Subject: 2021/93644 Erection and operation of grid-connected solar photovoltaic farm LOW FARM, WAKEFIELD ROAD, GRANGE MOOR, WAKEFIELD, WF4 4BB
Date: 04 November 2021 16:26:52

The Proposal and Impact on Playing Field

In light of the above, Sport England **objects** to the application because it is not considered to accord with any of the exceptions to Sport England's Playing Fields Policy or with Paragraph 97 of the NPPF.

Drawing Information	
Scale	1:5000 @ A0
Stage	ISSUED FOR REVIEW
Drawing Name	Overall Layout
Drawing Number	B001
Designed By	Samuel Hogan
Sheet 1 of 1

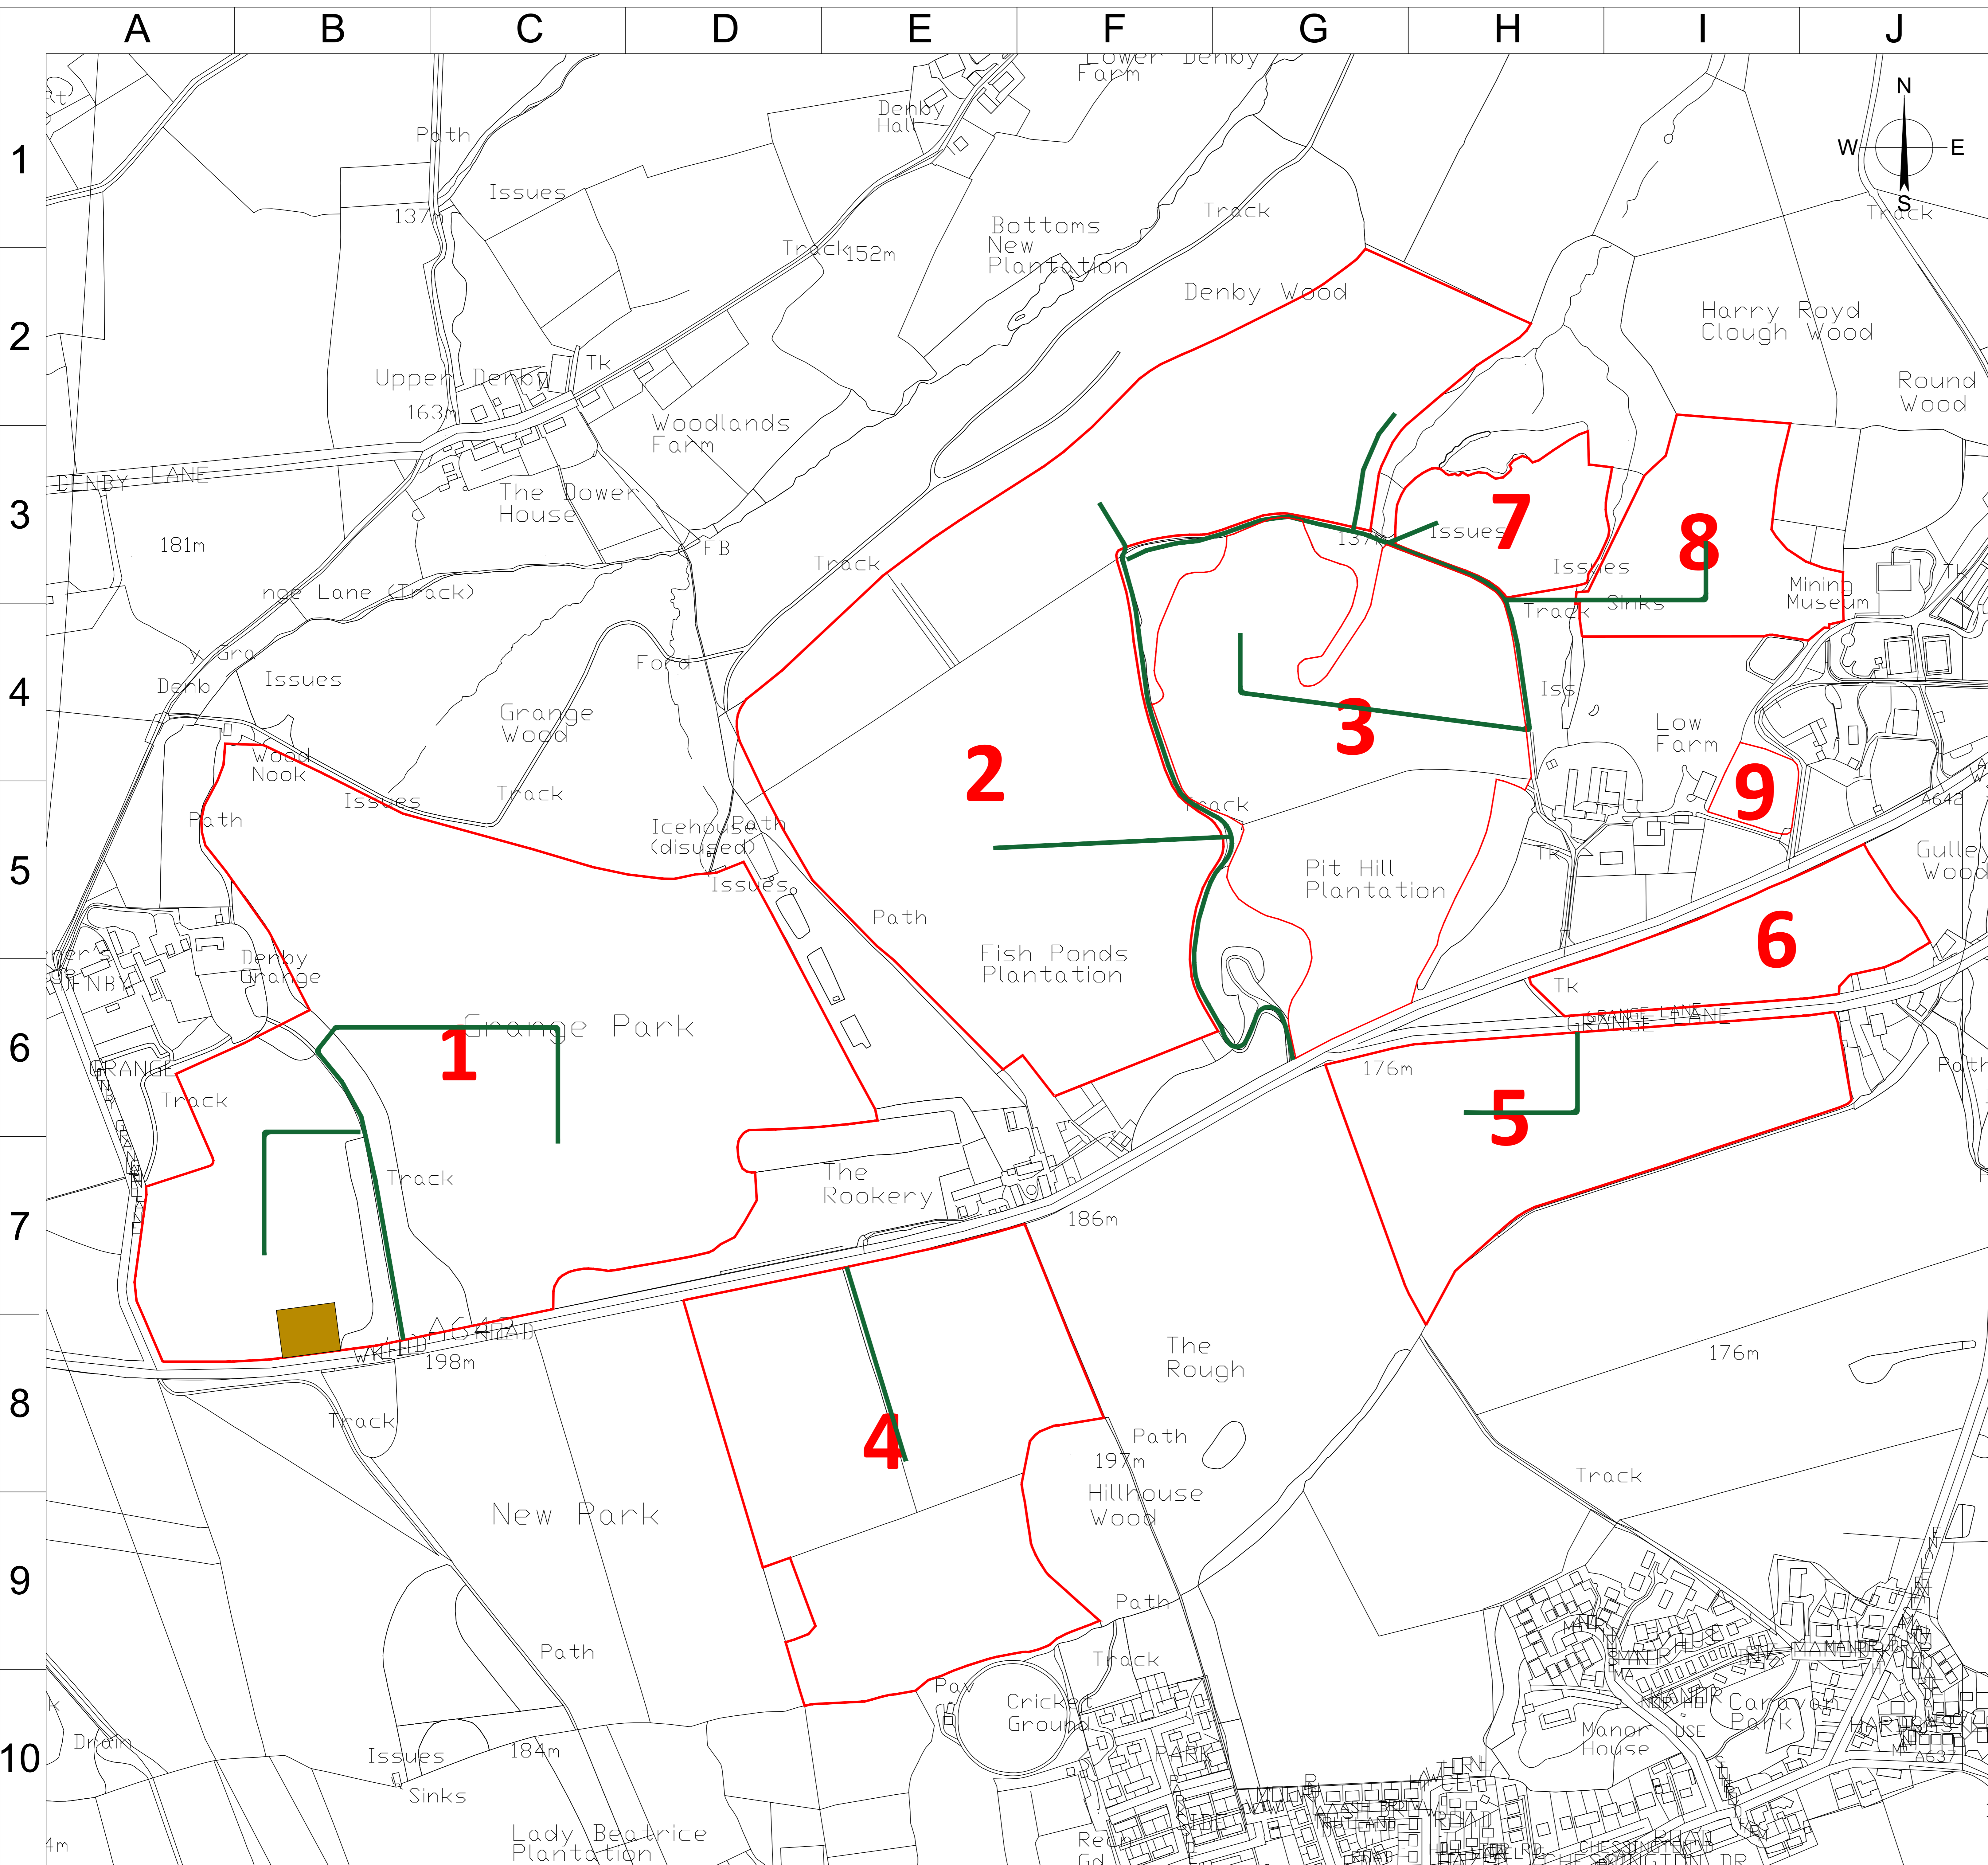
Part of the application site lies adjacent to a cricket ground, with some of the photovoltaic panels lying within 80m of the ground's wicket area. They are therefore at risk of ball-strike and damage from cricket balls.

Sport England notes and concurs with the ECB's response. As it stands there is likely to be a problematic relationship between the edge of the development and the adjacent cricket ground which might prejudice the future of the cricket ground. This is contrary to playing field policy.

- 1 Amend the area of photovoltaic panels so that none were within an 80m radius of the cricket ground's wicket; or
- 2 Undertake a ball-strike assessment report and amend the application to include ball-stop netting

recommended in the report.
